## DECISION DELEGATED TO DEVELOPMENT MANAGER

**Application No:** H16-0527-20      **Applicant:** Mr D Burchnall  
**Proposal:** Conversion of existing garage into self contained dwelling  
**Location:** Rear Of: 72 St Thomas Road Spalding  
**Terminal Date:** 28th August 2020

Site Block Plan

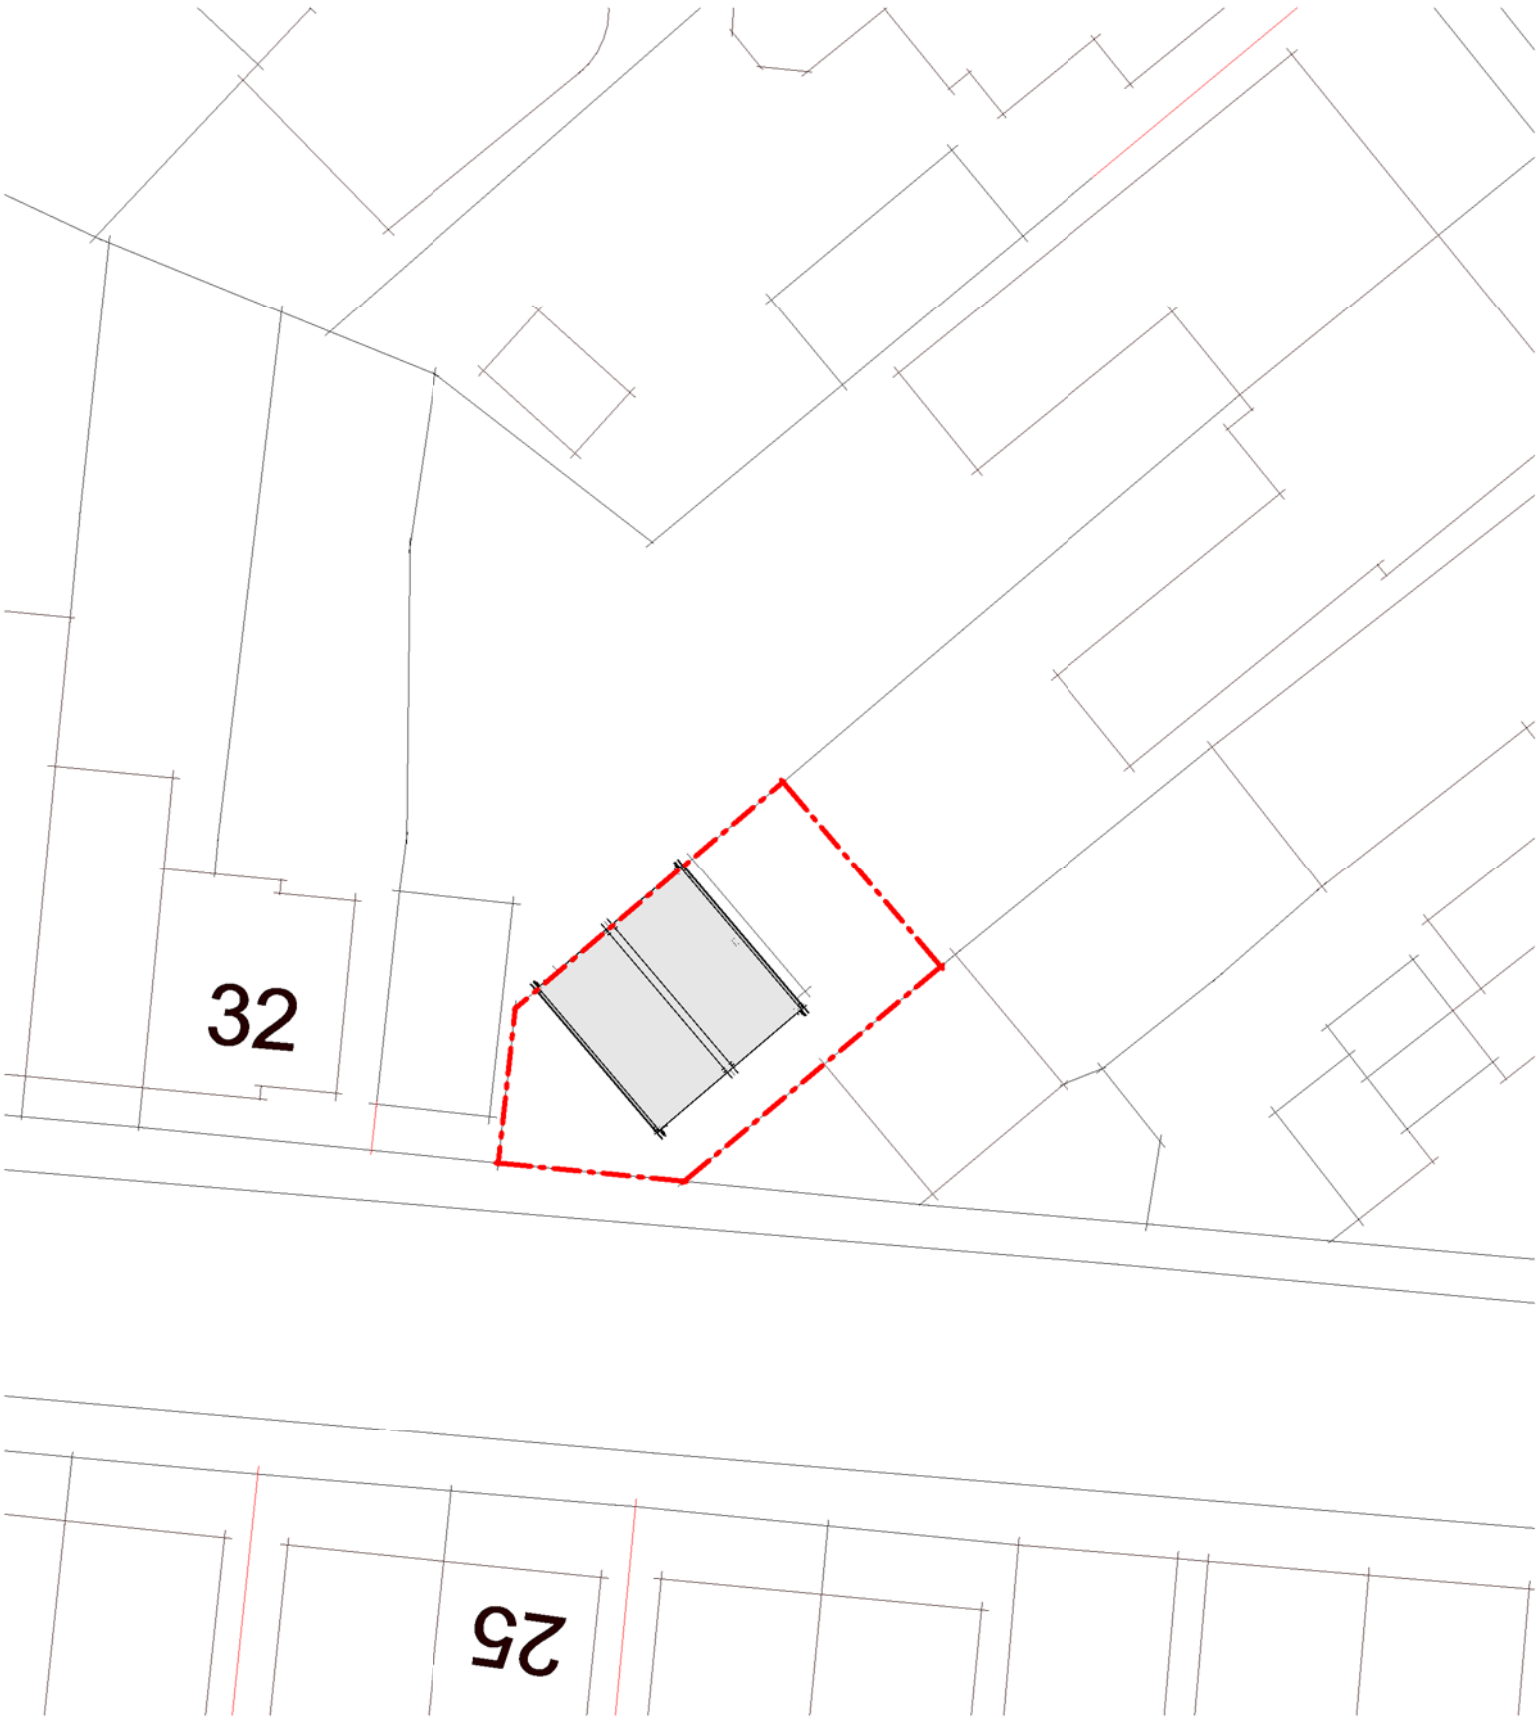
The purpose of the garage and driveway is to provide off road parking provision for the occupants of 72 St Thomas Road. The garage can accommodate a vehicle, with the driveway able to accommodate two further vehicles. If this provision was lost then there is currently no provision for off road parking for the property. This would further exacerbate parking provision problems in St Thomas Road and Cross Street where a number of Houses of Multiple Occupancy (HMO) are sited.

The proposal meets the minimum standards for parking spaces for the new dwelling, however it will lead to the loss of three off road parking spaces for the occupants of 72 St Thomas Road. The applicant has not sought to provide off road parking elsewhere on site.

Plan 01 - Ground
1 : 50

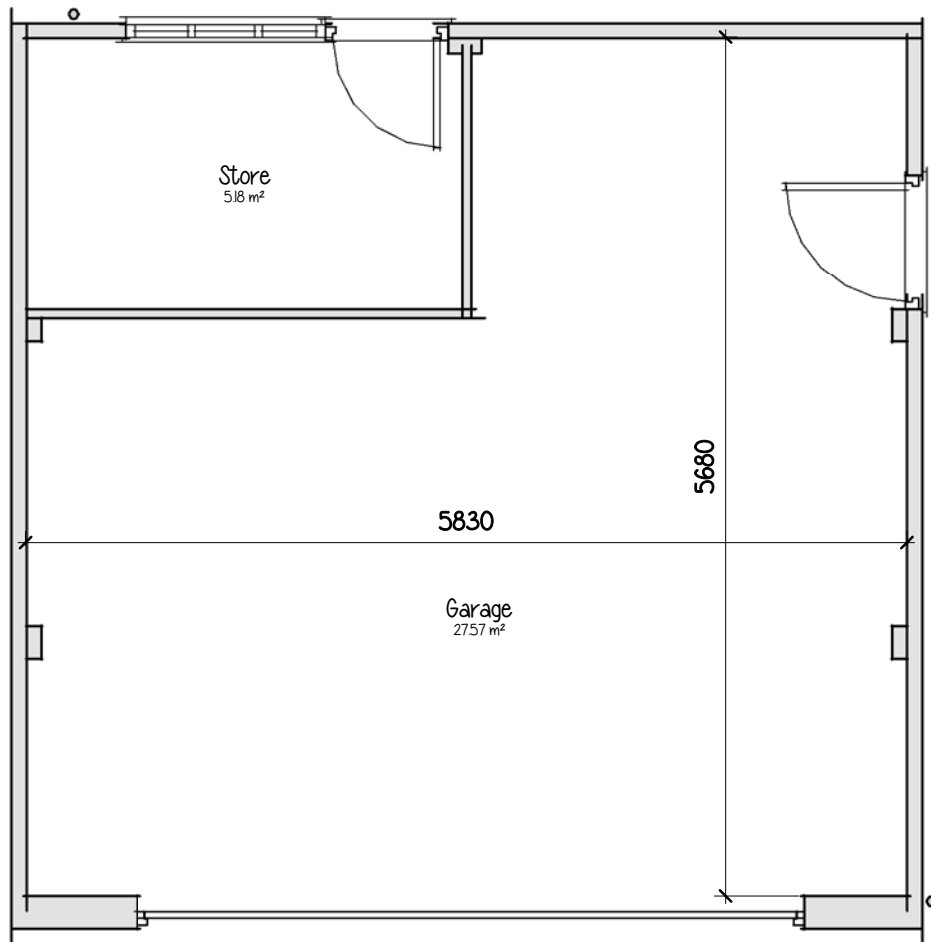
The garage measures 6.05 metres by 6.1 metres so the internal floorspace will be smaller than this. There is only partial separation of the kitchen, bedroom and living room and the proposal does not allow for a large amount of amenity space for occupant.
